**RE: Review Comment Responses / Banning Lewis Ranch Village C
Colorado Springs, Colorado**

The purpose of this letter is to respond to CDOT Staff review comments (1st Review). We have provided detailed responses to the review comments and made revisions to the Traffic Impact Study as applicable. We remain available to discuss further if needed. The following is a summary of comment responses:

**BANNING LEWIS RANCH - VILLAGE C**  
LAND USE PLAN  
COLORADO SPRINGS, CO  
LAND USE PLAN

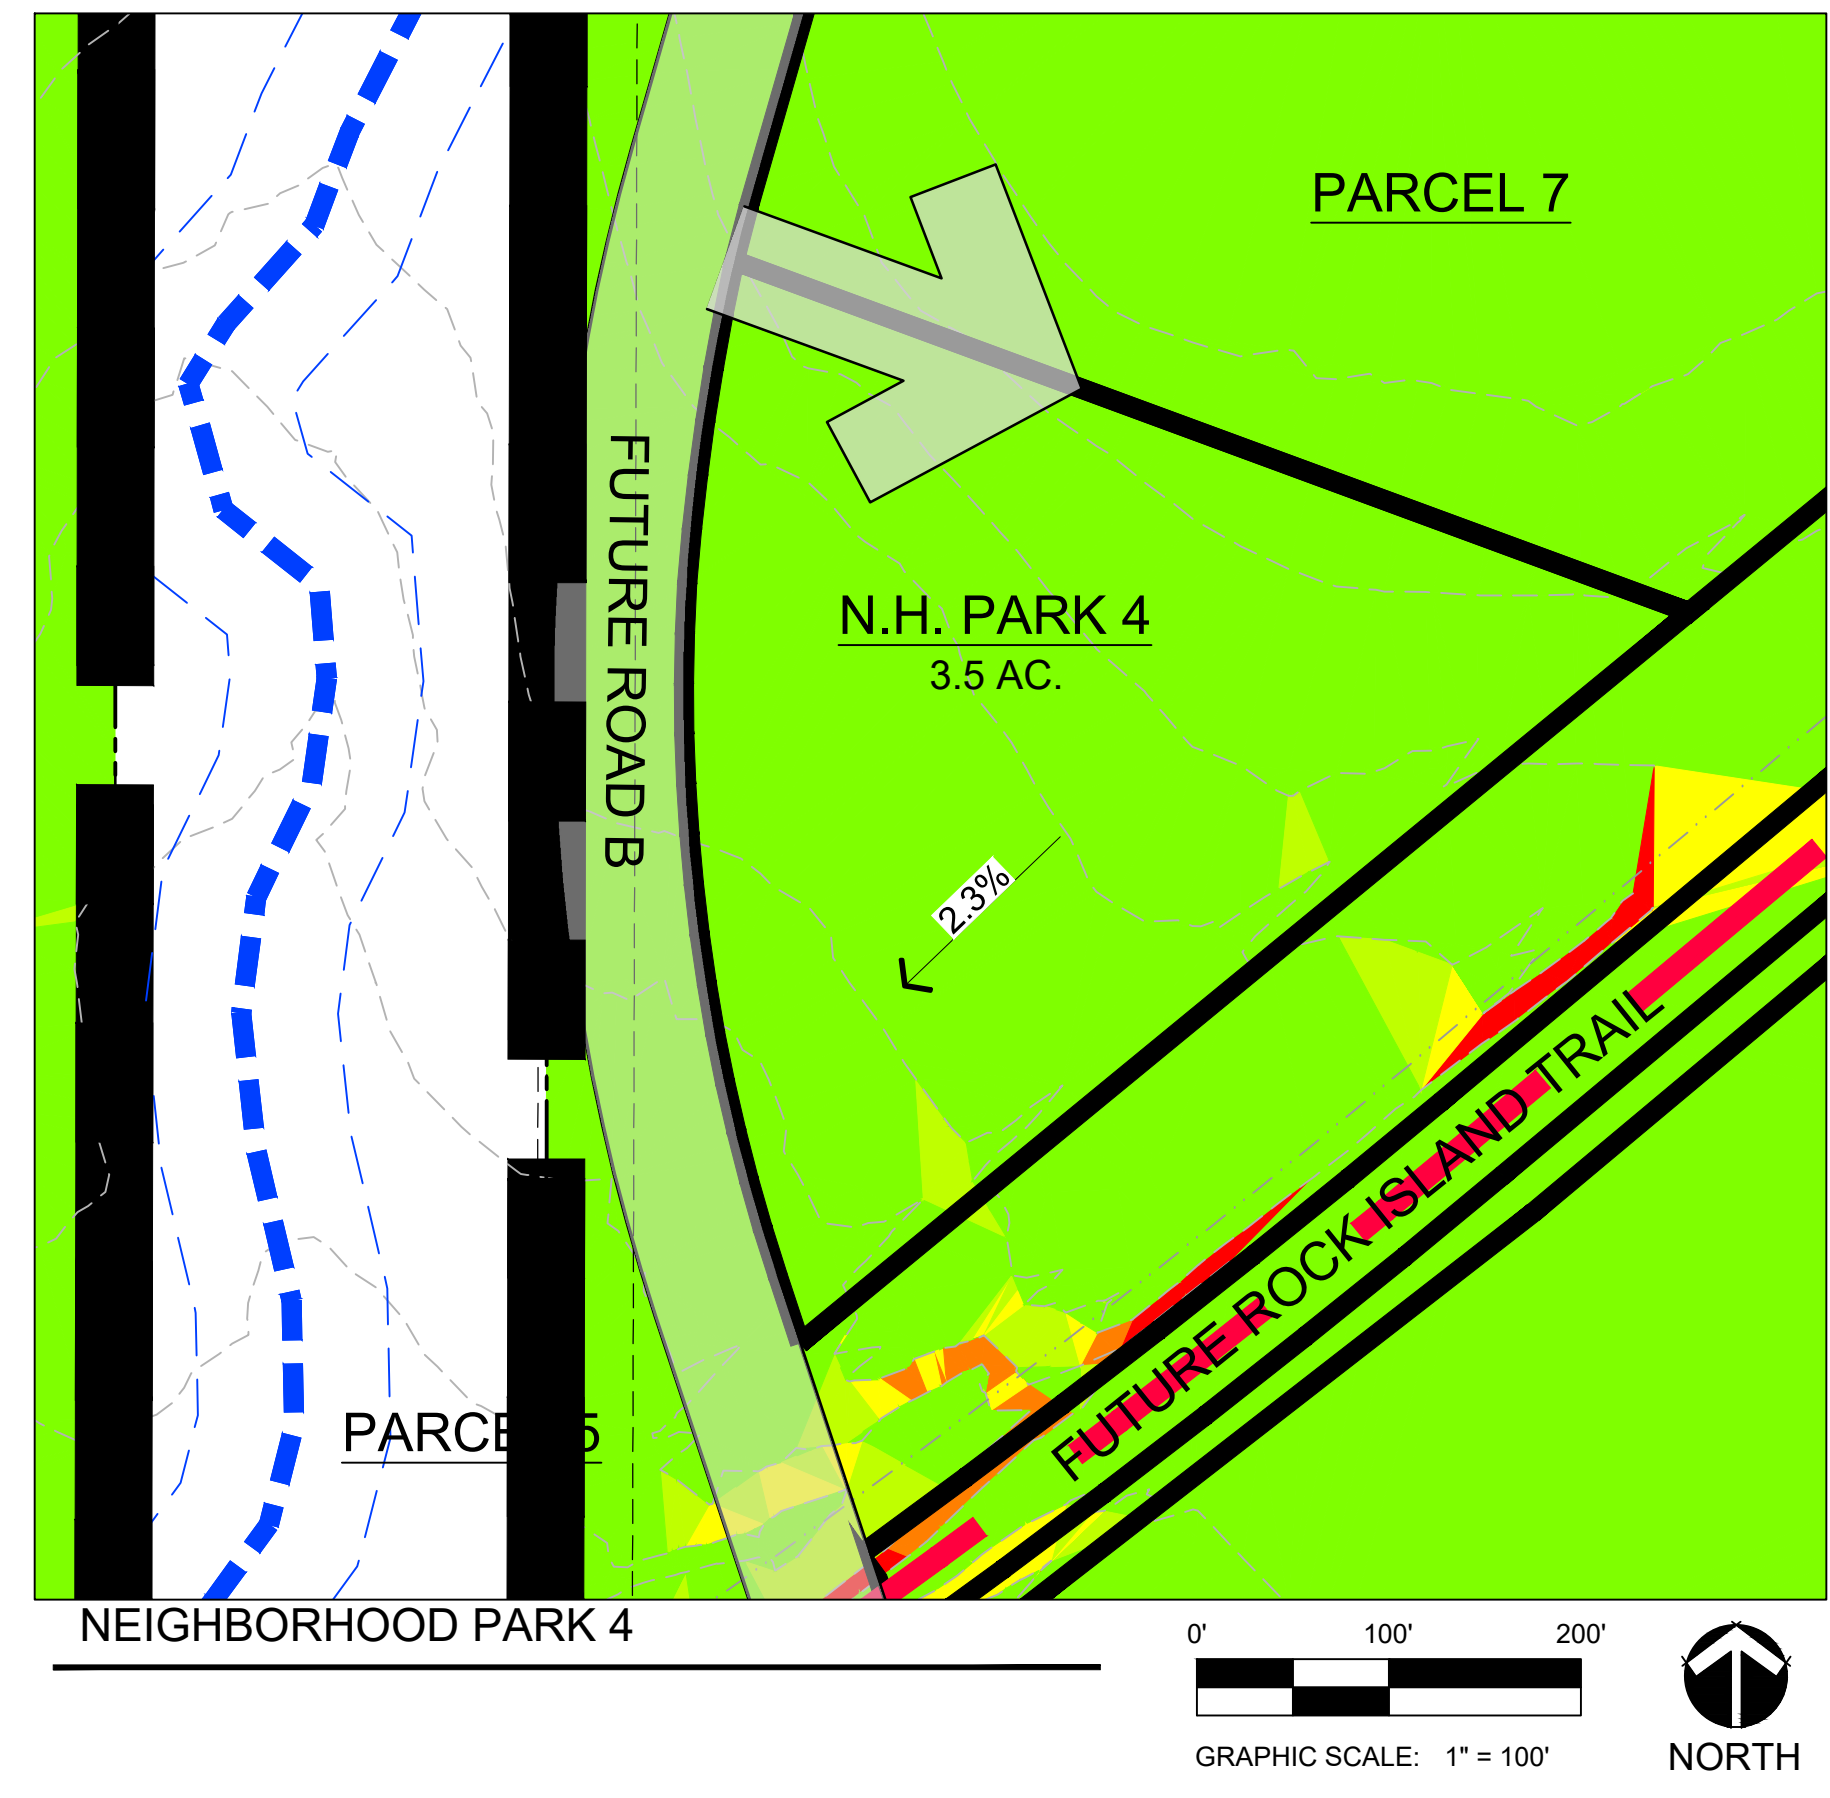
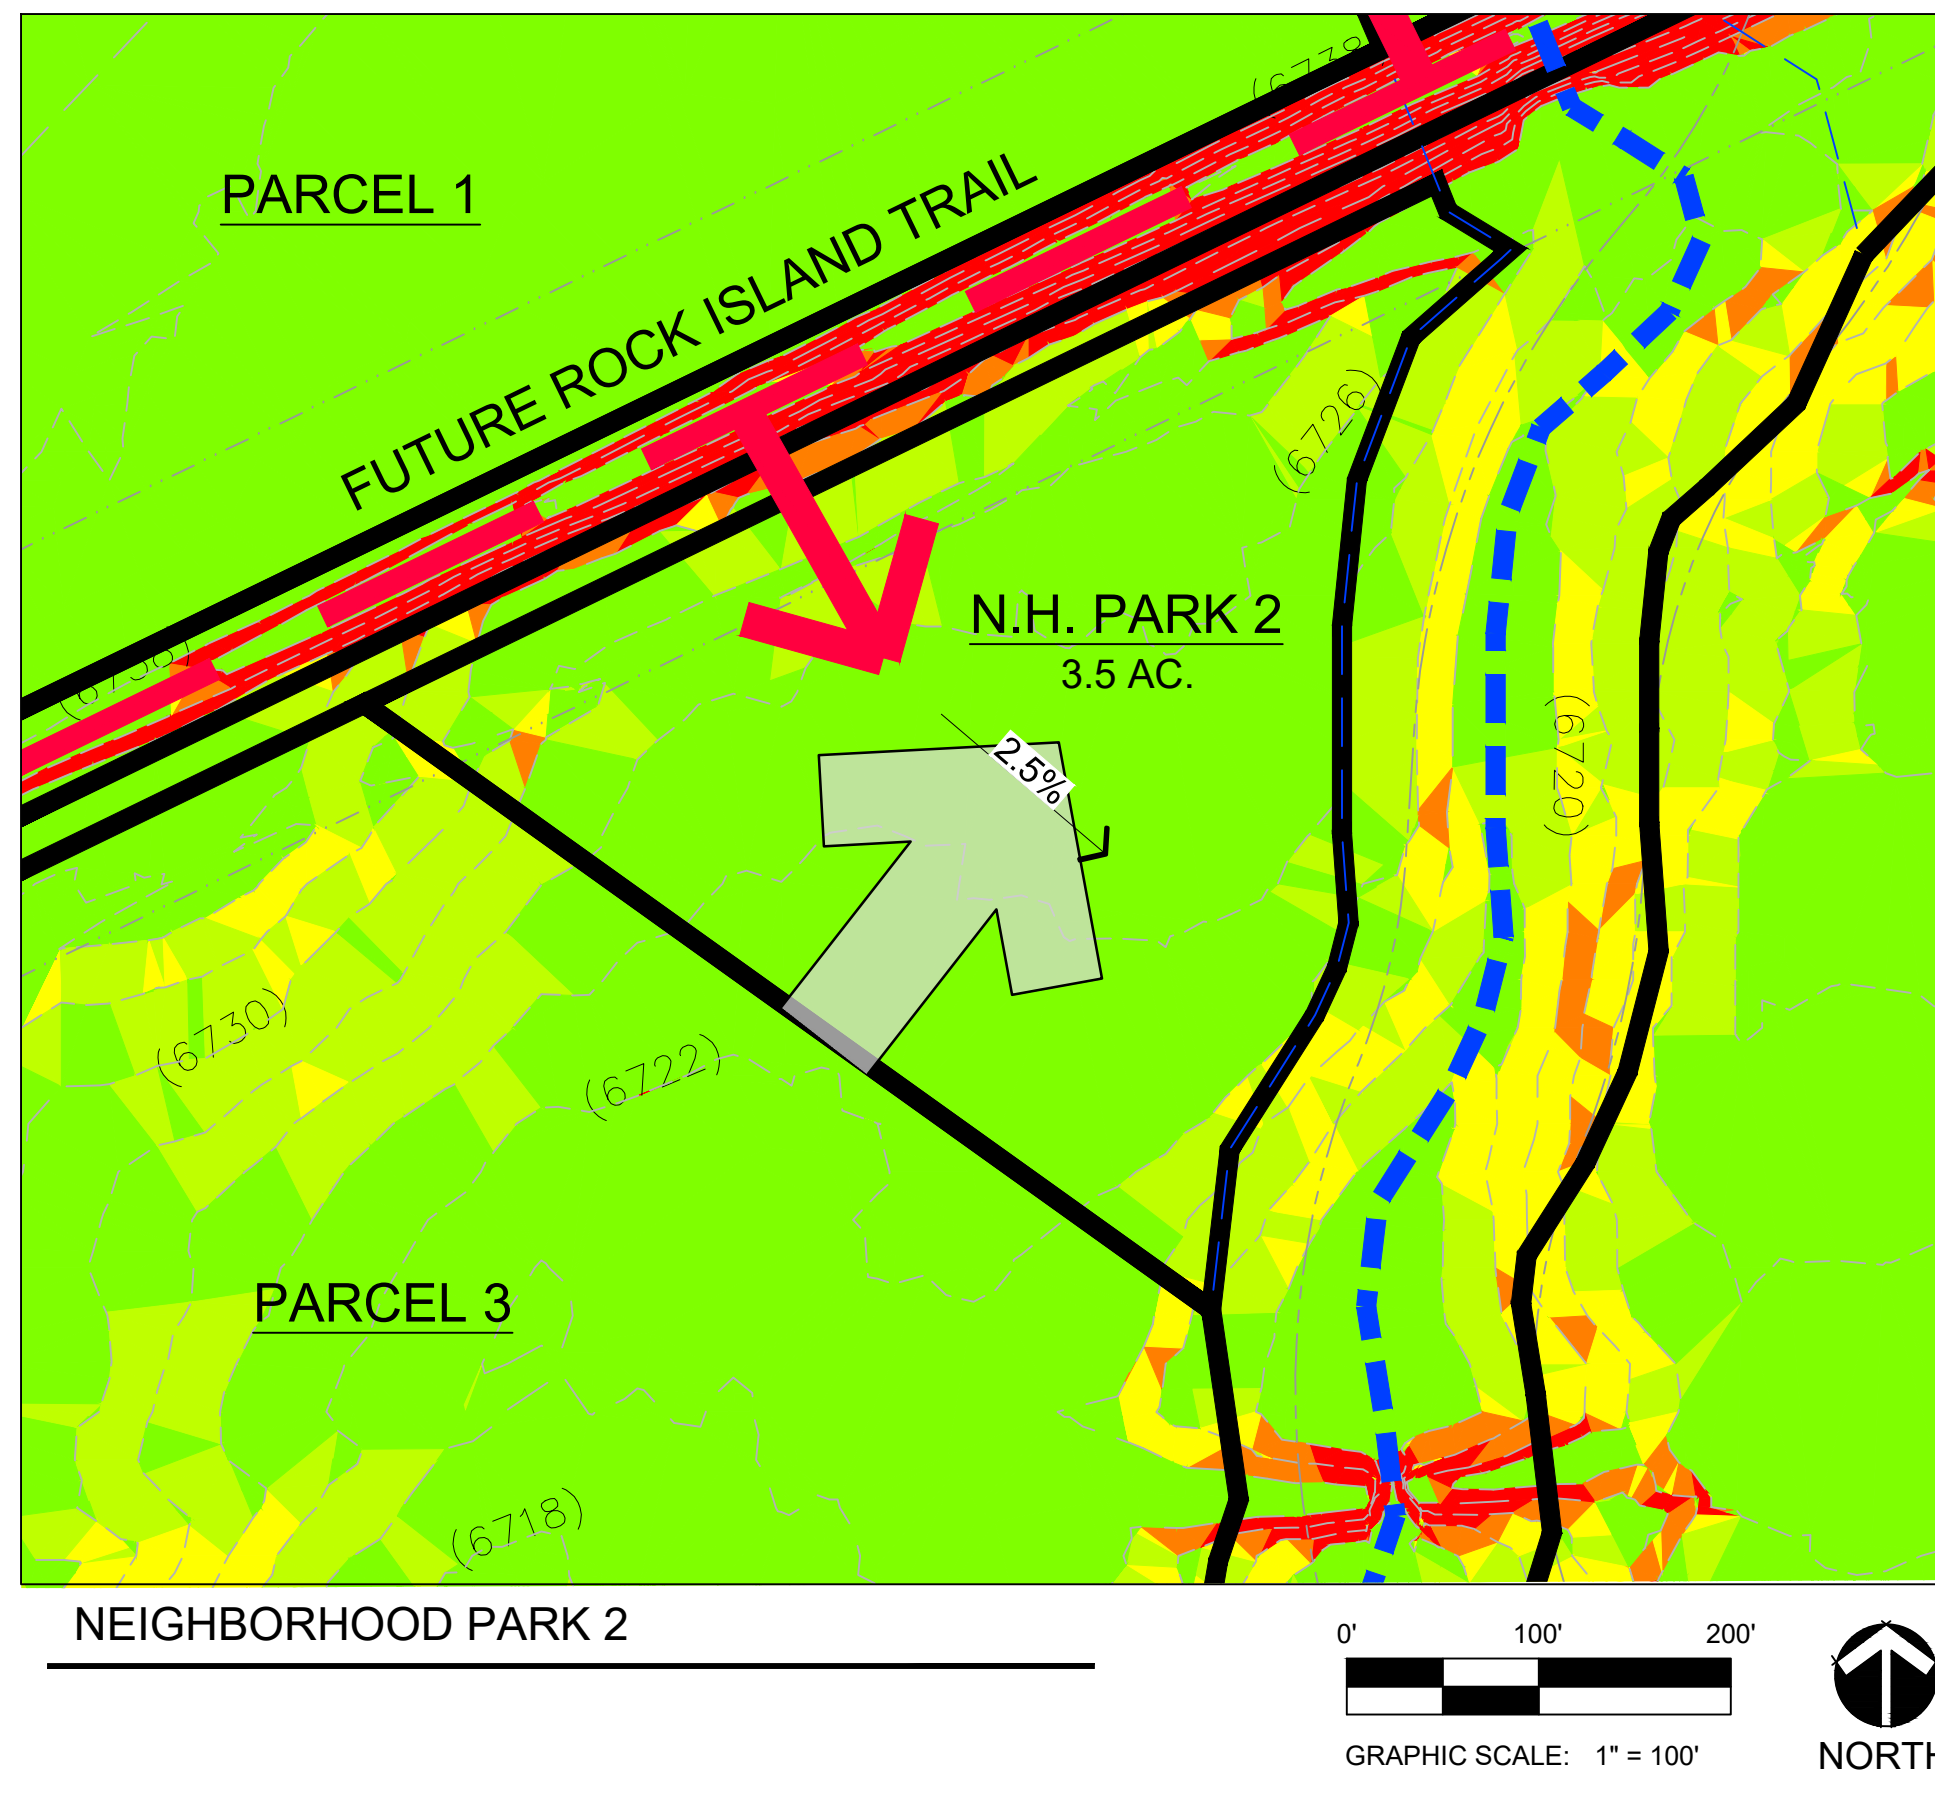
CDOT Staff Comment 4: Eliminate #11 access to US-24 and instead connect Dublin Blvd. to Falcon Hwy

Comment Response: Access Removed.
